# M25 junction 10/A3 Wisley interchange TR010030

## 8.3 Statement of Common Ground with Environment Agency

### 8.3 STATEMENT OF COMMON GROUND WITH ENVIRONMENT AGENCY

<b>Version</b>	<b>Date</b>	<b>Status of Version</b>
Rev 1	28 January 2020	Deadline 3
Rev 0	June 2019	Development Consent Order application

9.21 Scheme Layout Plans Annotated with Works Numbers (Reference 1.1.4 ExQ1)

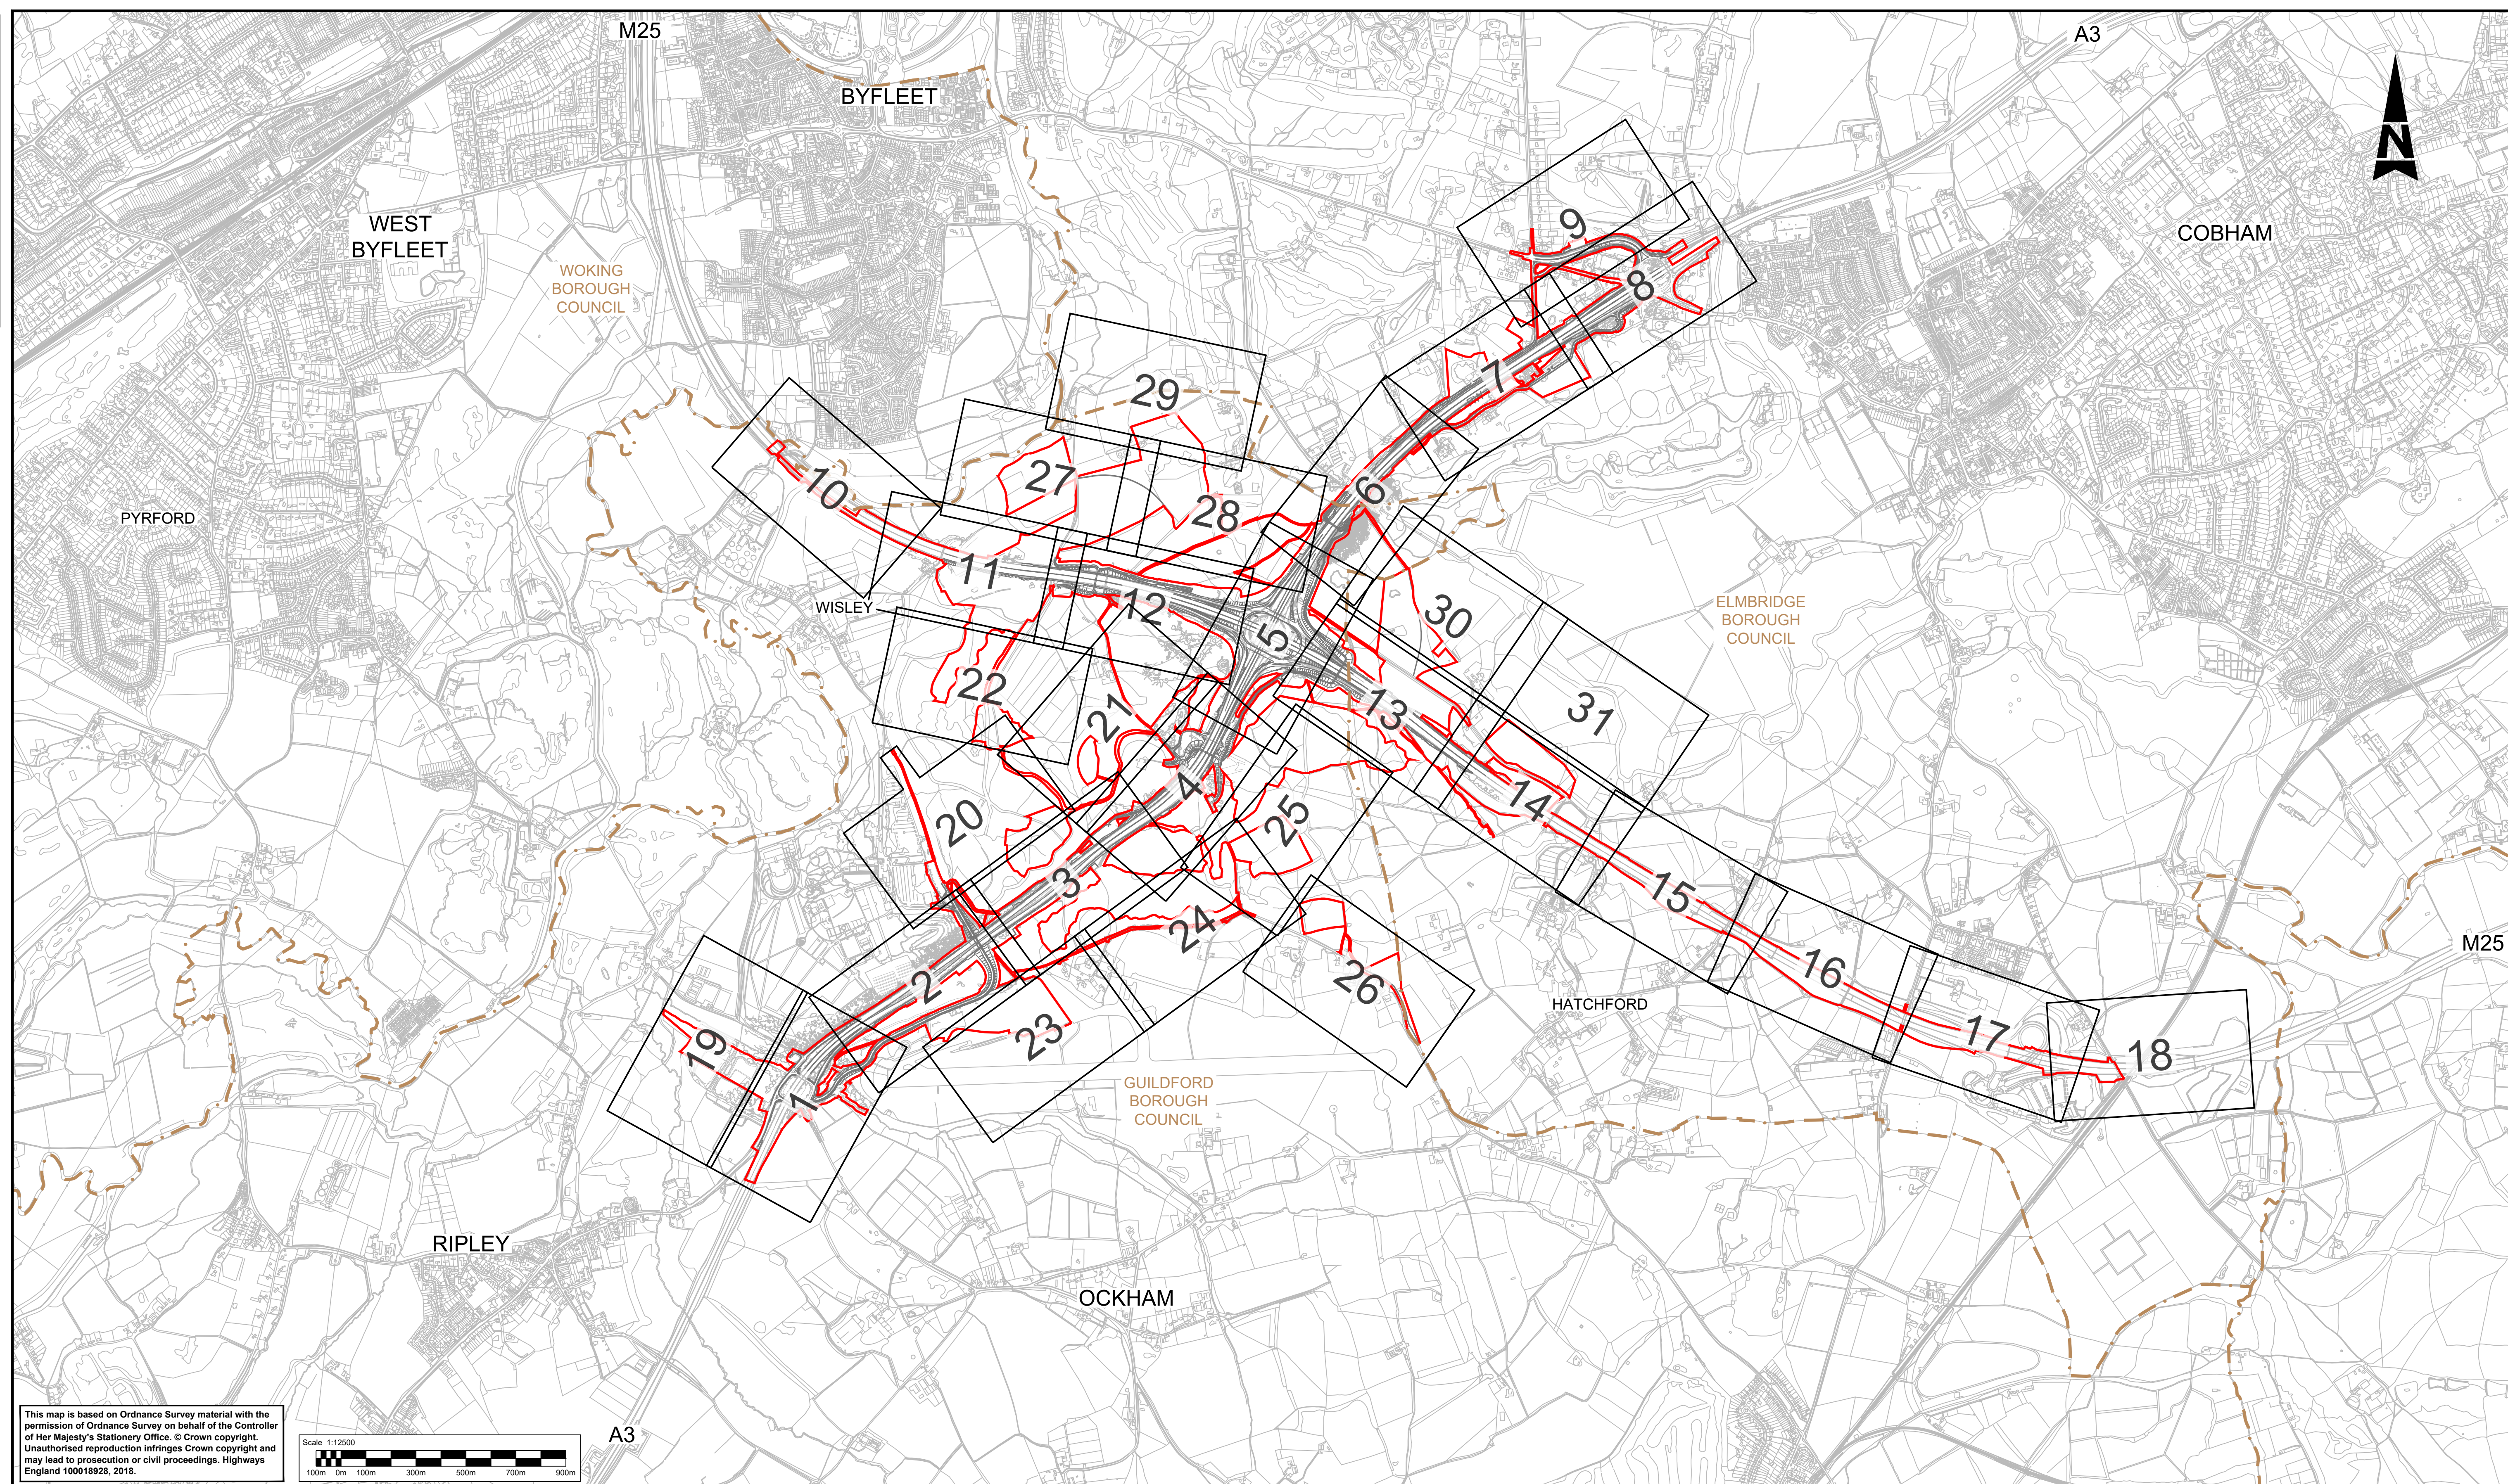
3.1.6	WFD Assessment Comments Log (CL): 028	Stratford Brook Crossing	Paragraph 5.4.3 of the WFD report states that “the bridge deck should run perpendicular to the watercourse (to reduce shading)”. The EA are	The planform of Stratford Brook at the New Stratford Brook Underbridge is shown on Sheet 1 of the Scheme Layout Plans	Agreed

Issue	Sub-section	Environment Agency Comment	Highways England Response	Status
			<p>concerned that the bridge deck isn't running perpendicular to the watercourse and that this could necessitate the need for bed and bank reinforcement later down the line. Highways England should provide justification for this alignment.</p>	<p>(APP-012). Structural details for the bridge are provided on page 57 of Engineering Drawings and Section (APP-014). The bridge crosses a sinuous reach of the brook. Fitting this multi-curve meander shape into the rectangular shape of a bridge is a challenge that has principally been addressed by designing a bridge with a very wide span. The abutments of the span are broadly parallel with the most likely (downstream) progression of the meander under the bridge, lowering the risk of the river making contact with the bridge into the future. The design represents a sensible balance between accommodating the needs of the water environment with the alignment and constructability of the road. The EA were satisfied with this justification for the alignment of this bridge at a meeting on 08 October 2019 (A.43).</p>

Issue	Sub-section	Environment Agency Comment	Highways England Response	Status
			bridge deck so that it's perpendicular to the watercourse.	life and critical infrastructure. Highway's England will review the means by which amendments to the WFD can be made during the DCO process if considered necessary. Suggested rewording to "bed and bank protection should only be used where an erosion hazard cannot be avoided (for instance by relocating an abutment or pier) and a real risk to life or critical infrastructure is apparent". The EA were satisfied with this justification at a meeting on 08 October 2019 (A.41).
